SB 29-A00105B

BUILDING INSPECTION
PERMIT

This is to certify that DUNKERLY MARY V / Architect Type P A subject
has permission to Change of use, Office/Condo Residential Conversion of 1st floor
AT 150 MIDDLE ST P01 029 A001P01

Proposed Use: Residential Condo Change of use, Office Condo to Residential Condo w/ fit-up on 5th floor	Proposed Project Description: Change of use, Office Condo to Residential Condo w/ fit-up on 5th floor
--	--

2 NEW SKYLIGHT SECTION
SCALE: 1/4" = 1'-0"

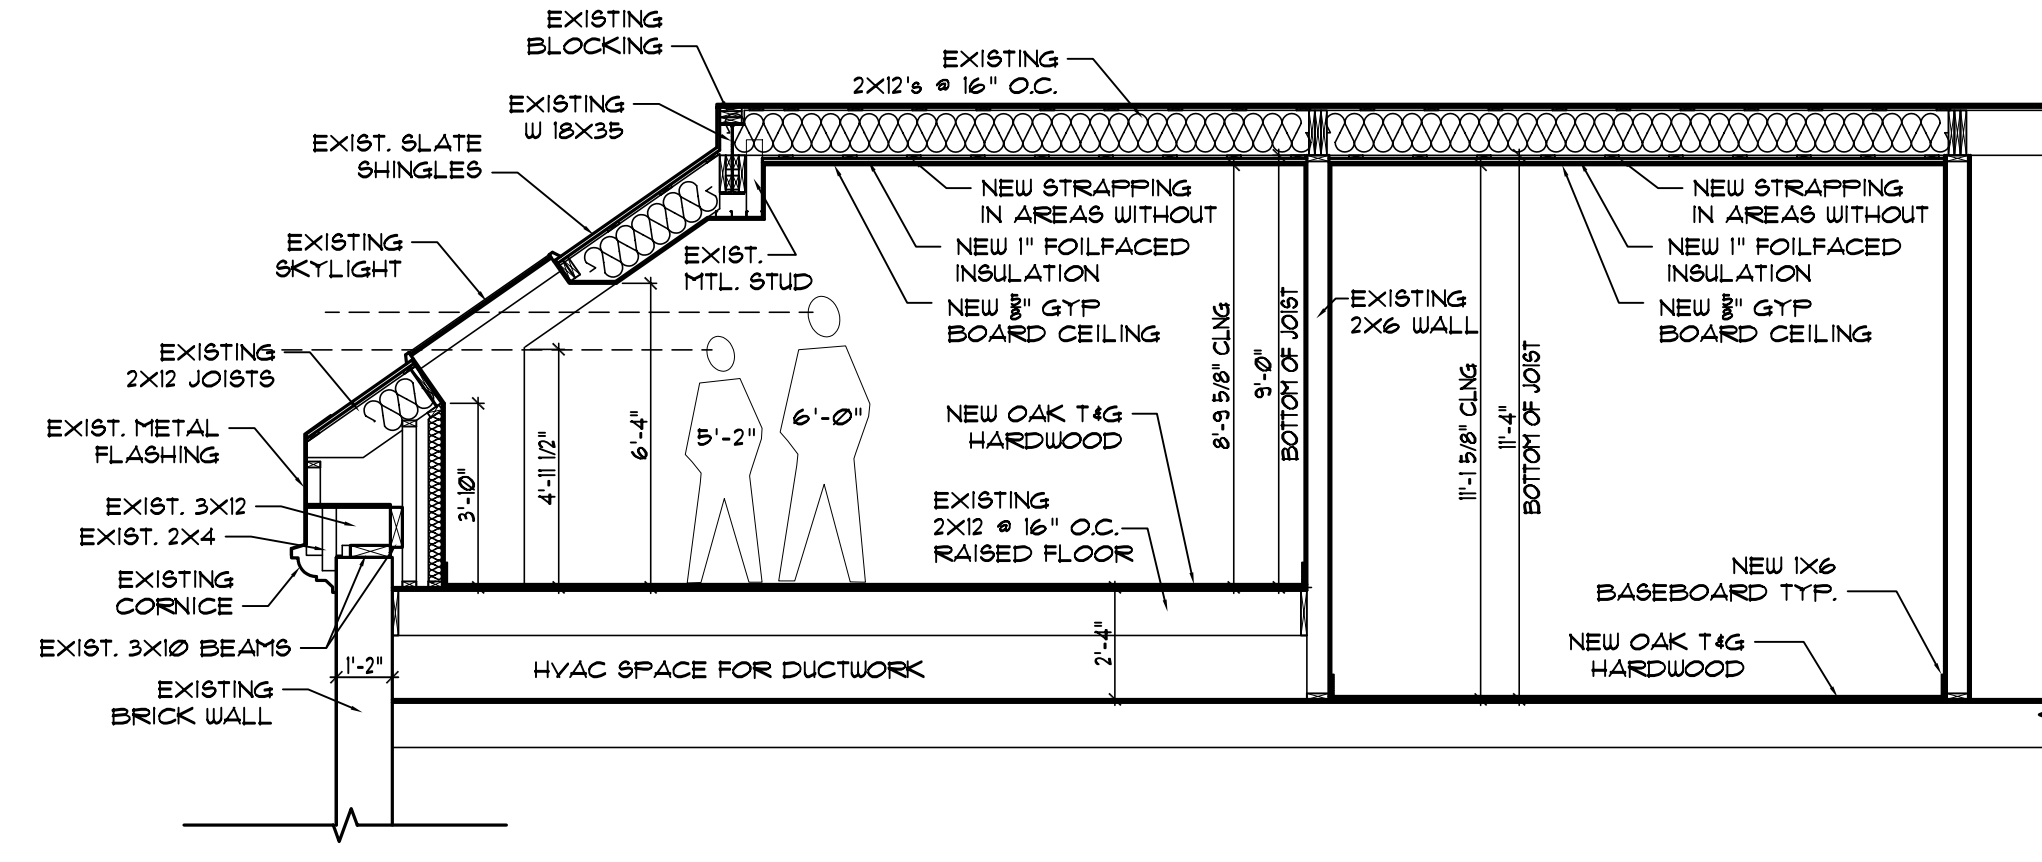
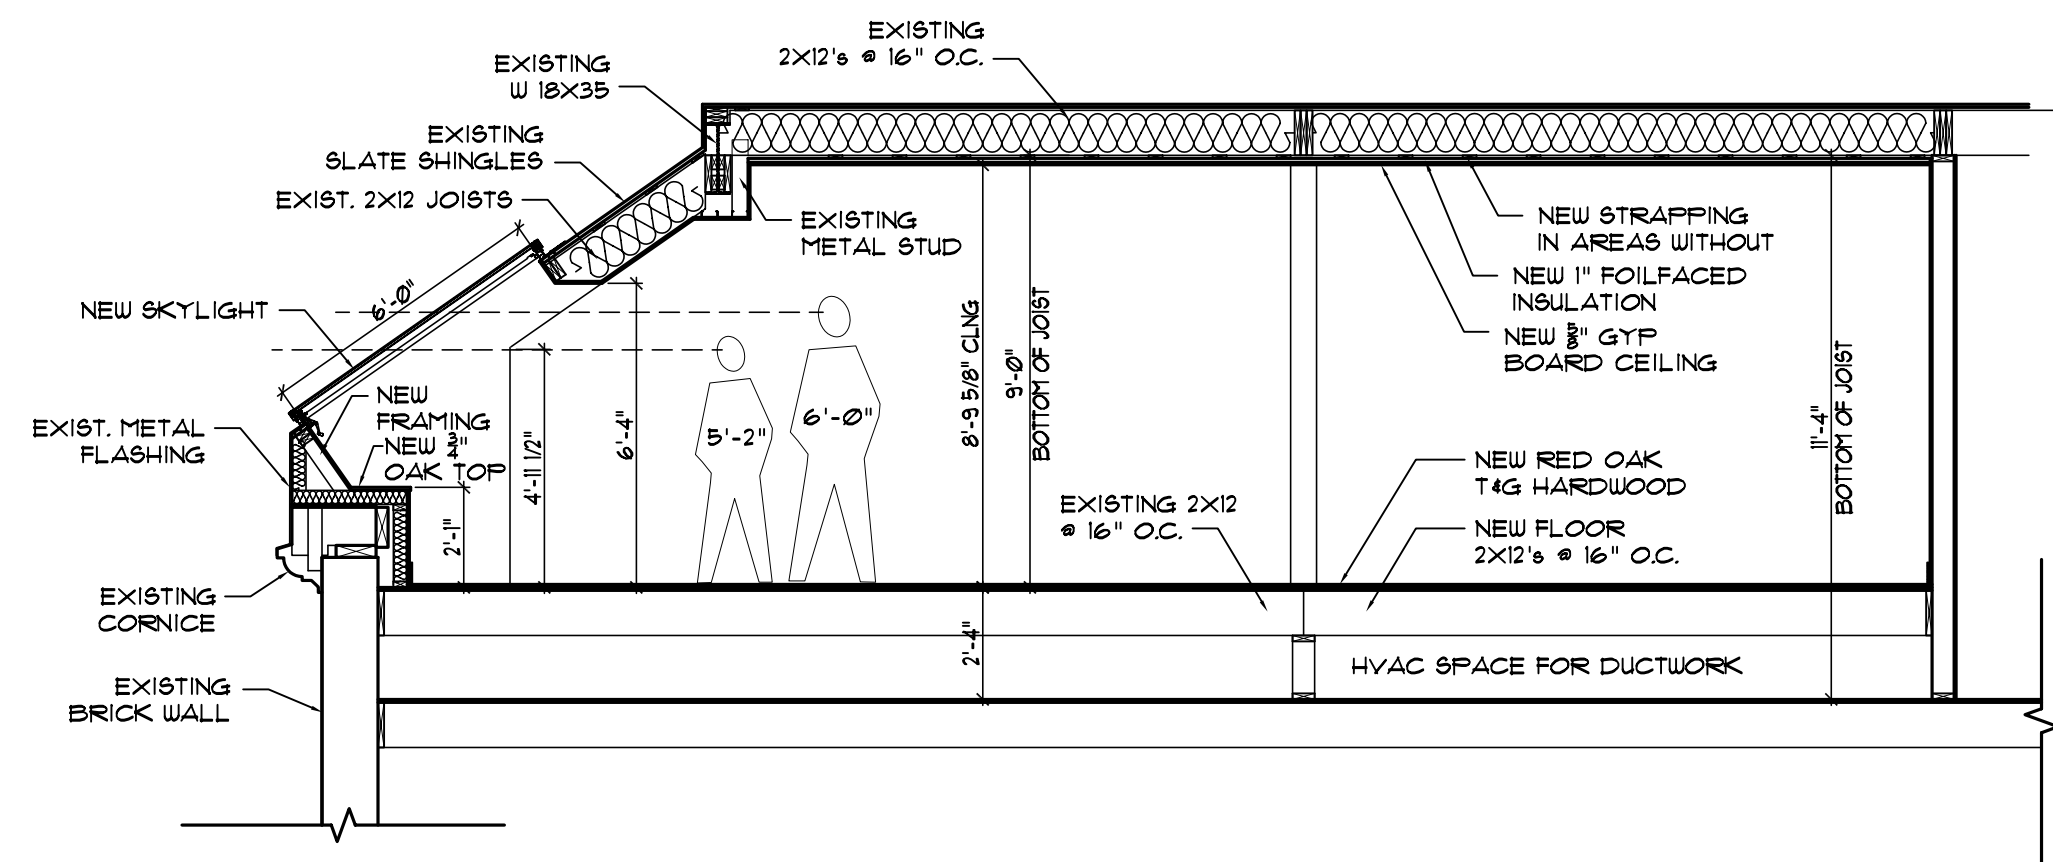
1) * Approval based on revised drawings---bottom edge of skylights to be held back from roof edge a minimum of 12 inches.			
Dept: Zoning	Status: Approved with Conditions	Reviewer: Ann Machado	Approval Date: 02/15/2007
Note:			Ok to Issue: <input checked="" type="checkbox"/>
